Planning Application Ref: 3/2017/0313

Description of Development: Outline Application for an Agricultural Worker's Dwelling

Site Address: The Poultry Unit, Tosside Road, Slaidburn BB7 4TP

ADAS Assessment of Planning Application Ref: 3/2017/0313

Location Plan A3

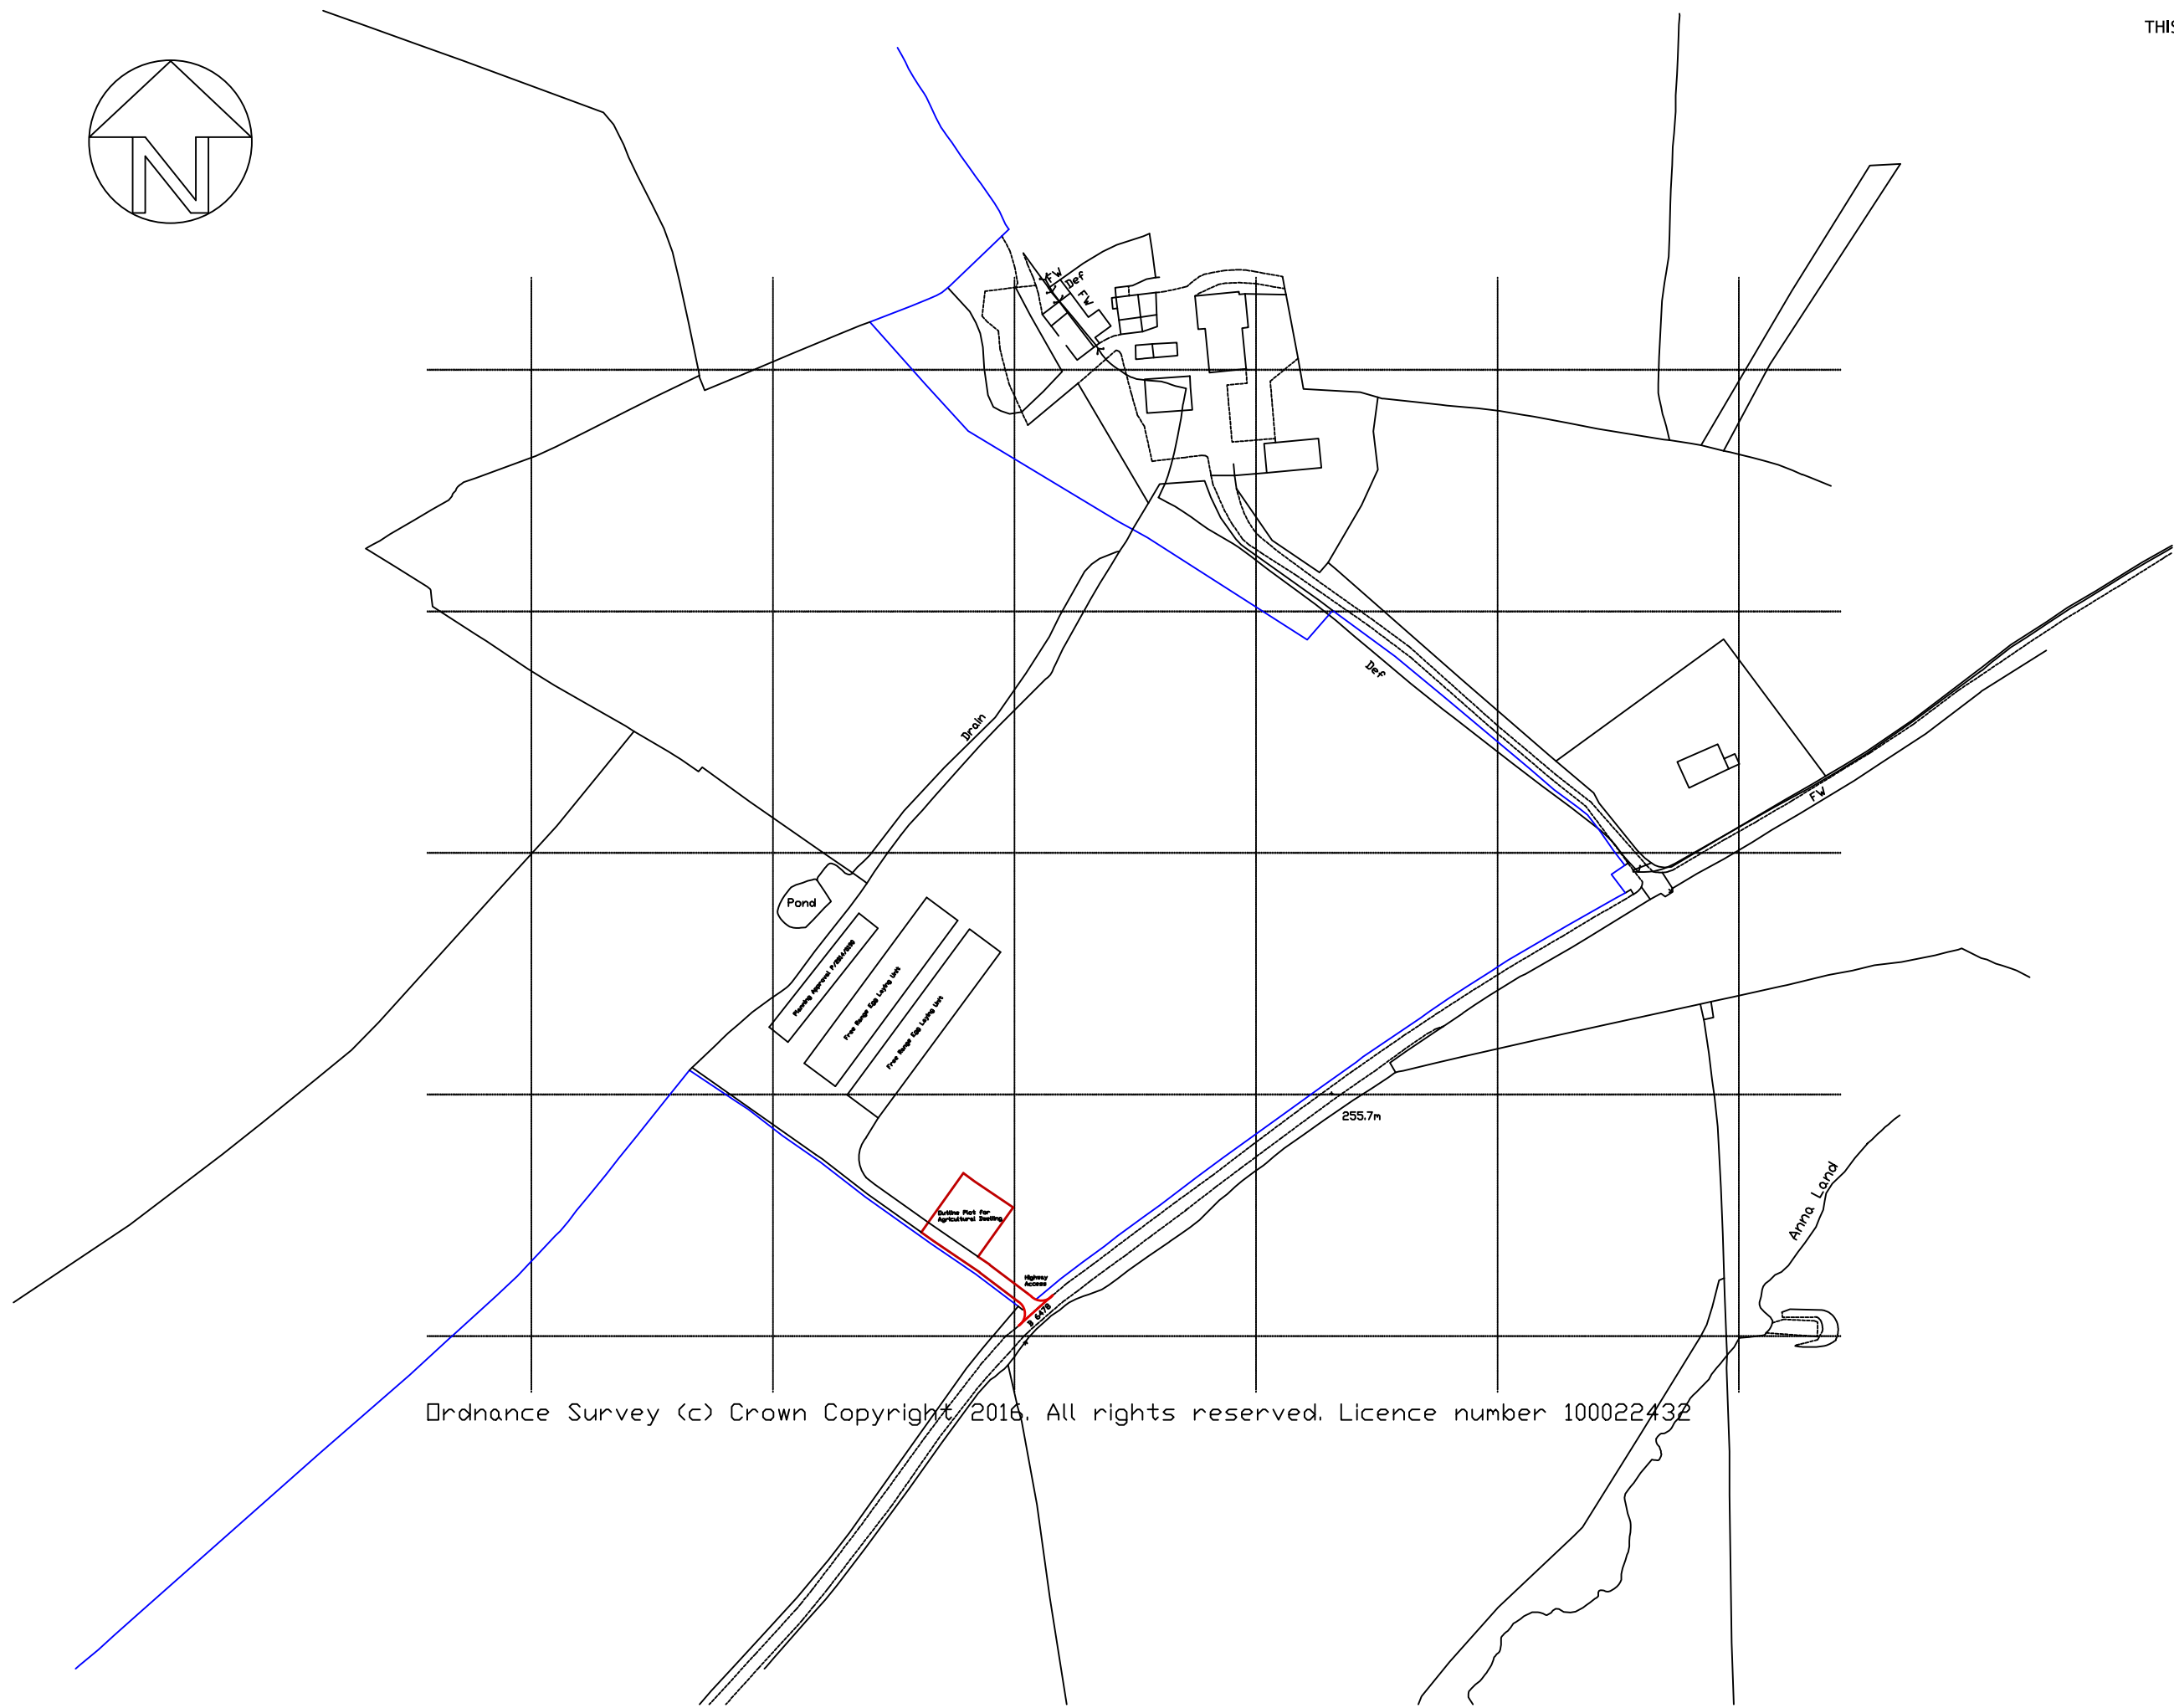
In order to satisfy the functional needs of the business, the dwelling would need to be located in reasonably close proximity to the buildings which are used to accommodate the poultry. The location plan that was submitted with the application shows an indicative siting of the proposed dwelling.

It is our opinion that the proposed siting is a suitable location to provide for the necessary supervision of the poultry unit and to provide for security to the property, as it is situated adjacent to the access road to the poultry unit.
